## **Amendments to Approved Level II Site Plan – Ocean Gateway Addition**

Project: Ocean Gateway Addition

Prepared For:	
Consulting Engineer:	
Architect:	ARCHETYPE architects 48 Union Wharf Portland, Maine 04101 (207) 772-6022 Fax (207) 772-4056
Project:	Addition to Ocean Gateway Garage 167 Fore St. Portland, Maine
Revisions:	
Date:	May 26, 2016
Scale:	As Noted
TYP. UPPER FLOOR PLAN	
A1.02

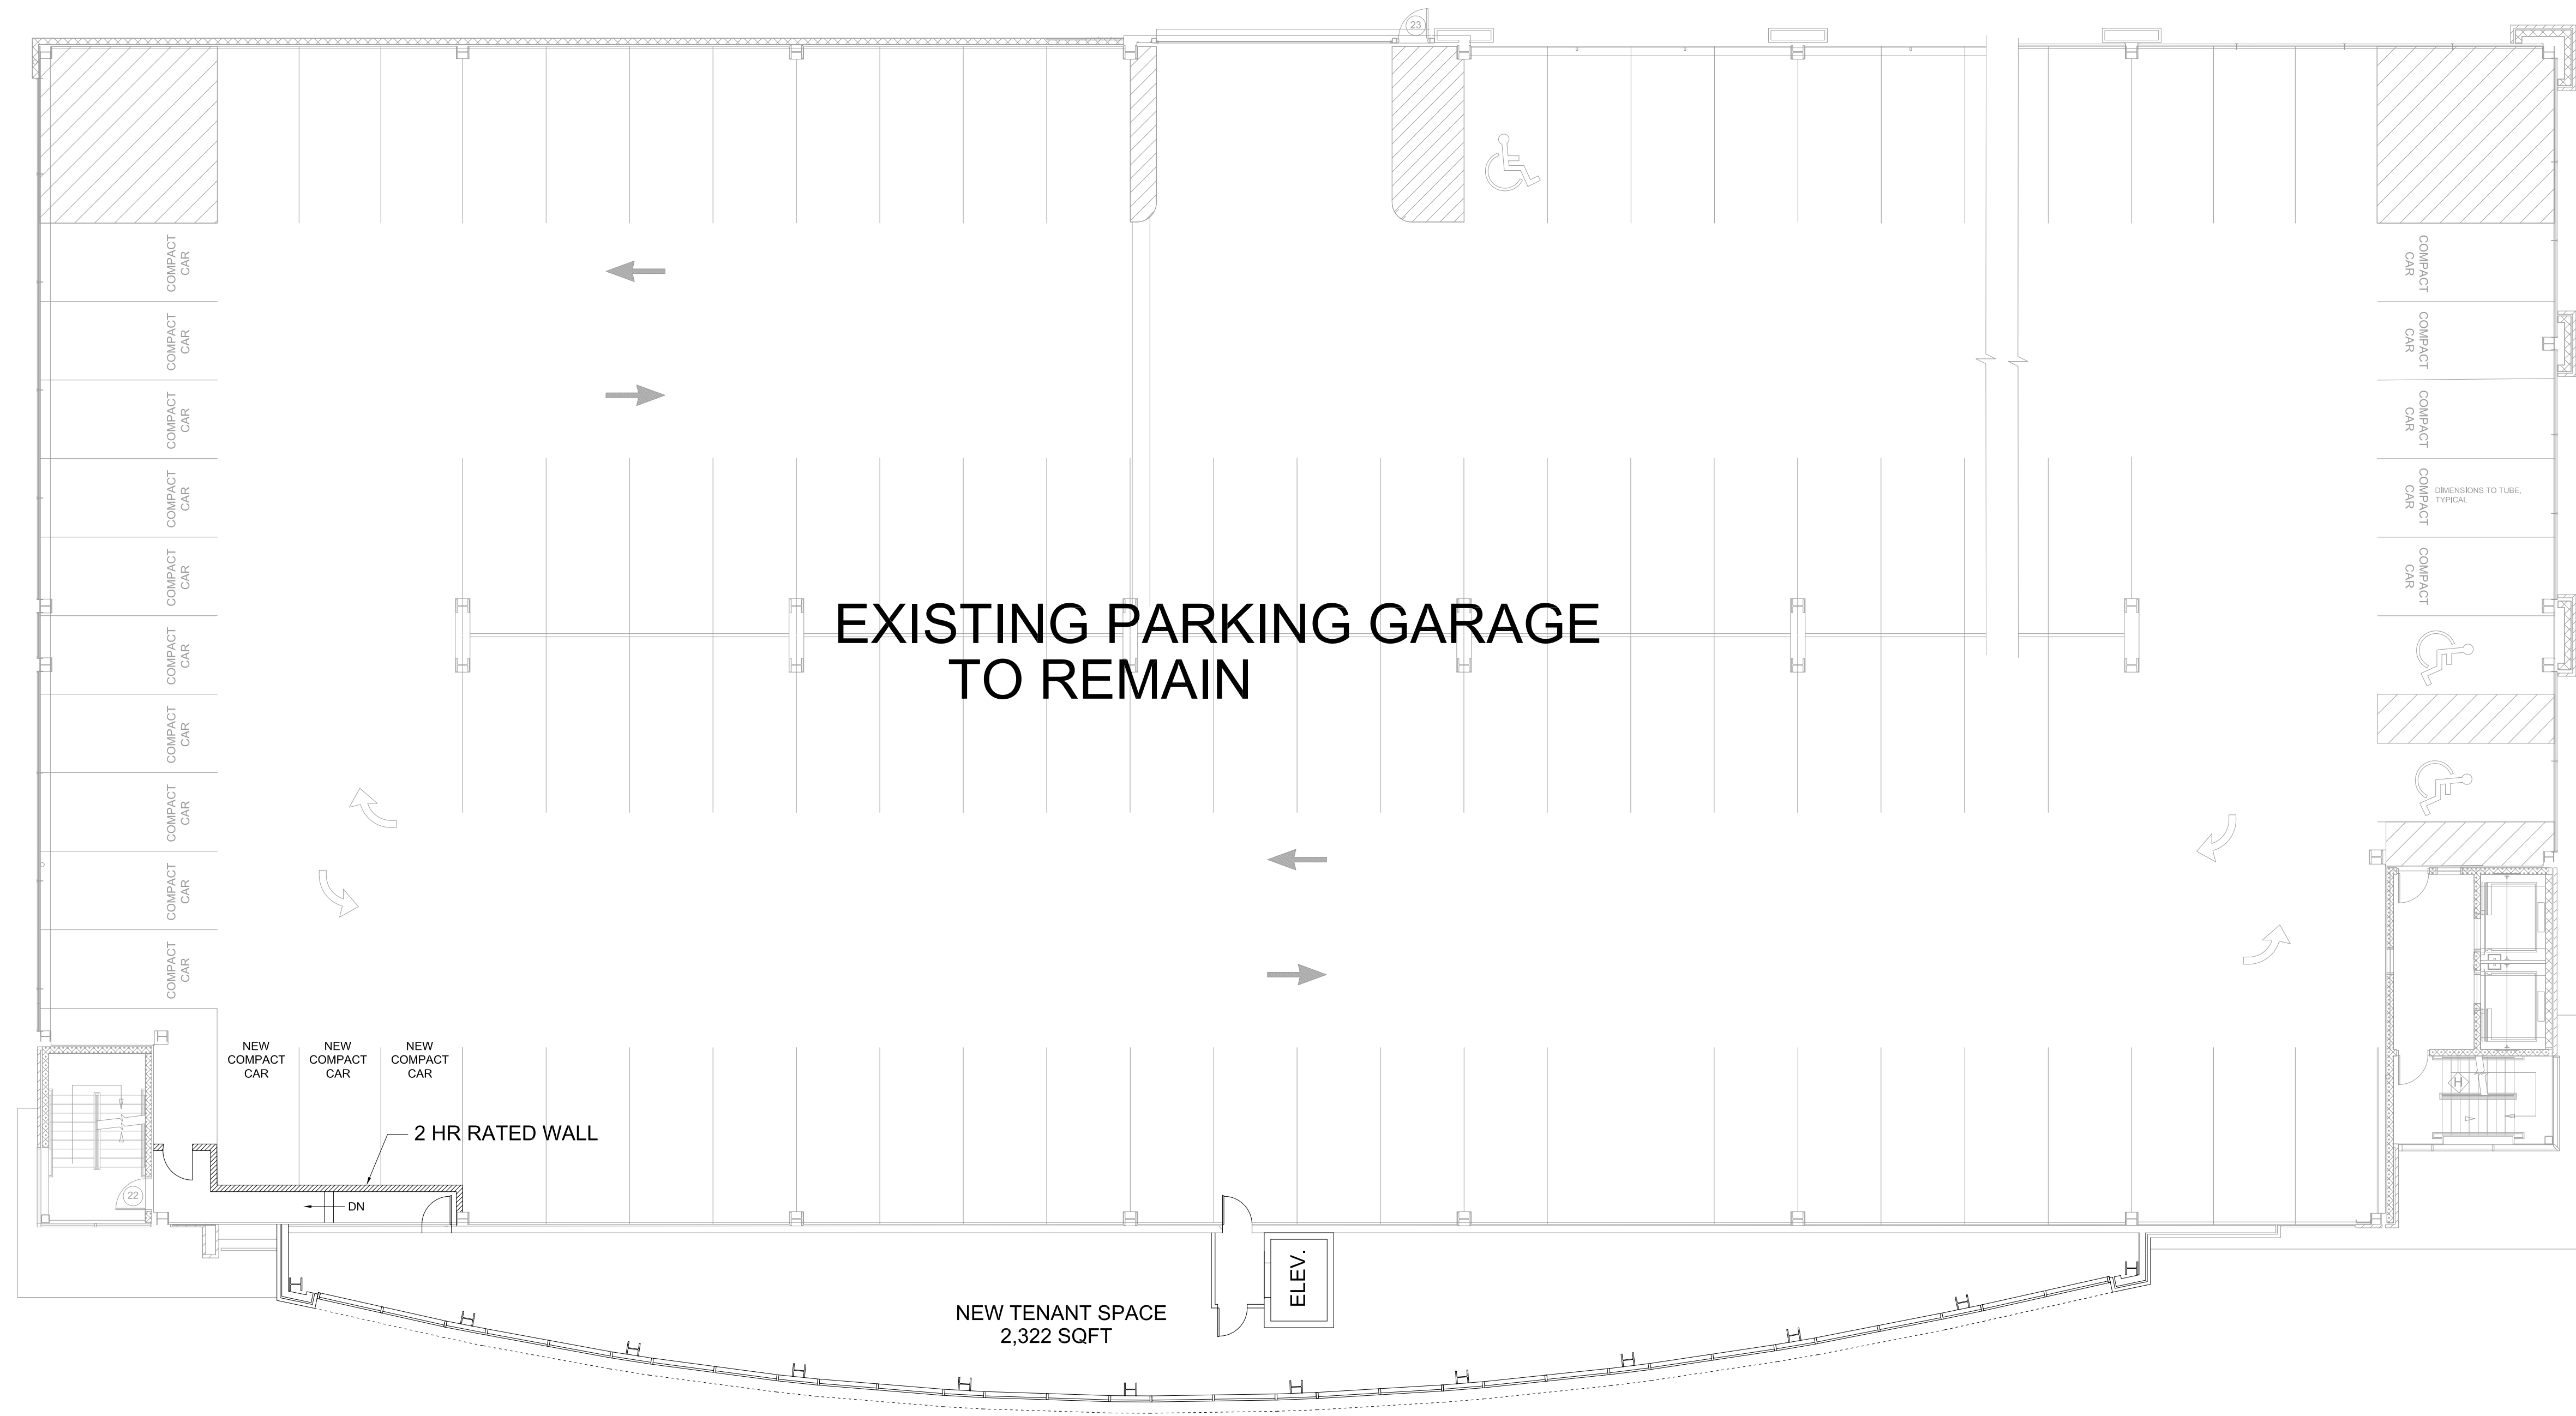
#### **Change in Occupancy From Residential to Office on the Top Floor:**

It was not feasible to the overall project to incorporate a residential use on the top floor of this addition. Due to cost implications of potential separation and code requirements, we kept the entire addition as an office occupancy.
